# ROLLING THUNDER BUSINESS PARK, LOT 12

EPC STORMWATER REVIEW COMMENTS IN ORANGE BOXES WITH BLACK TEXT

ROLLING THUNDER BUSINESS PARK - LOT 12	REVISIONS	DATE	BY	SHEETS
10707 MALTESE PT. PEYTON, CO				
<p>SK Design Group, Inc. 333 Perry St. Suite 209 Castle Rock, Colorado 80104 Phone: 913-451-1818 Fax: 913-451-7599</p>				
SK JOB NUMBER: 24-105	DESIGNED: AM	CHECKED: SM	APPROVED:	
DATE: 02-22-2024	DETAILED: EP			
<p><b>GESC COVER SHEET</b></p> <p><b>SHEET 1 OF 3</b></p>

**GESC PLAN**

ROLLING THUNDER BUSINESS  
PARK - LOT 12  
10707 MALTESE PT. PEYTON, CO

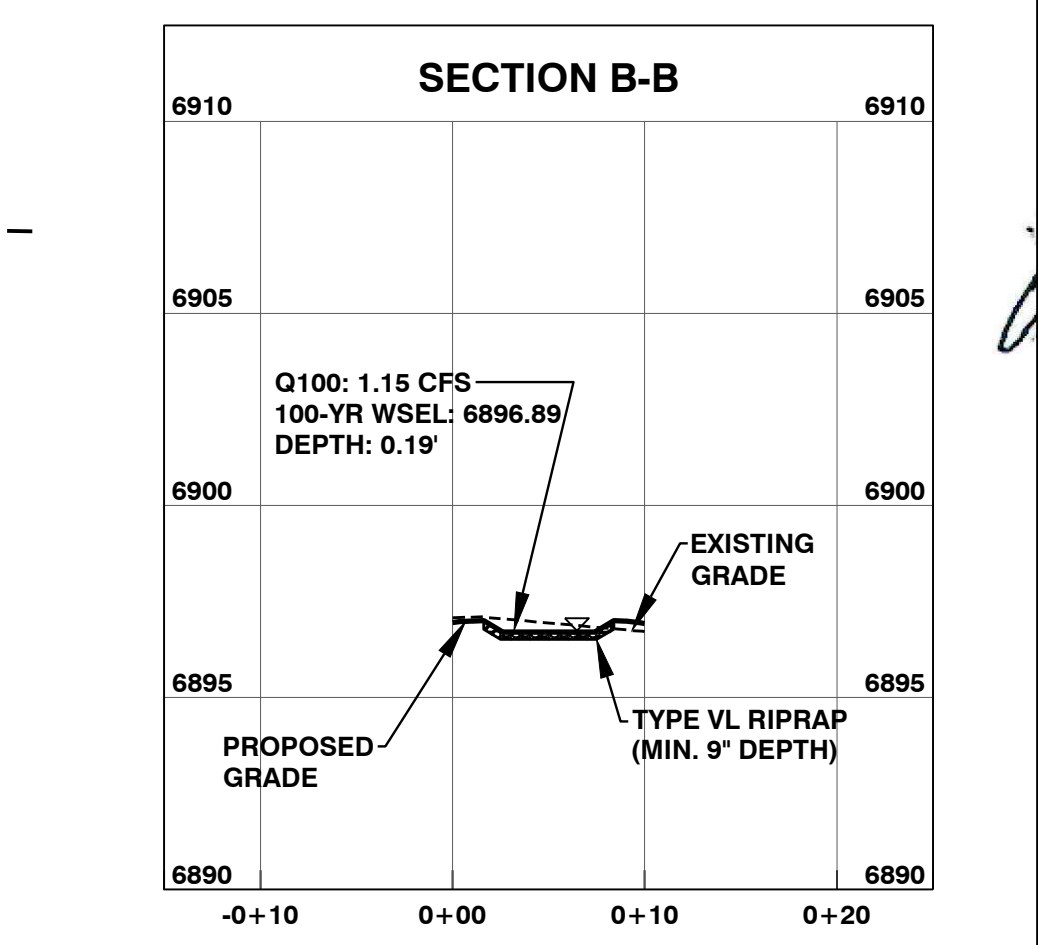
Please provide a name/number to the PBMP and then update all submitted text and drawings accordingly with consistent labeling throughout (example: "Pond A" or "Pond 1").

Provide emergency spillway, riprap, and details. Since this pond is only for WQCV storage and infiltration, large storms are going to overtop and we would be looking to see a localized location for bypass flows to release at.

Provide riprap or other erosion protection at concentrated inflow points.

Pond name has been created and is now shown on all relevant sheets and is referenced in the report. -SKDG

Grading has been revised to show emergency spillway, riprap has been added and spillway has been sized to convey the 100-yr flow from tributary basins to the drainage channel to the east. -SKDG

Riprap is now shown at concentrated inflow/outflow points. -SKDG
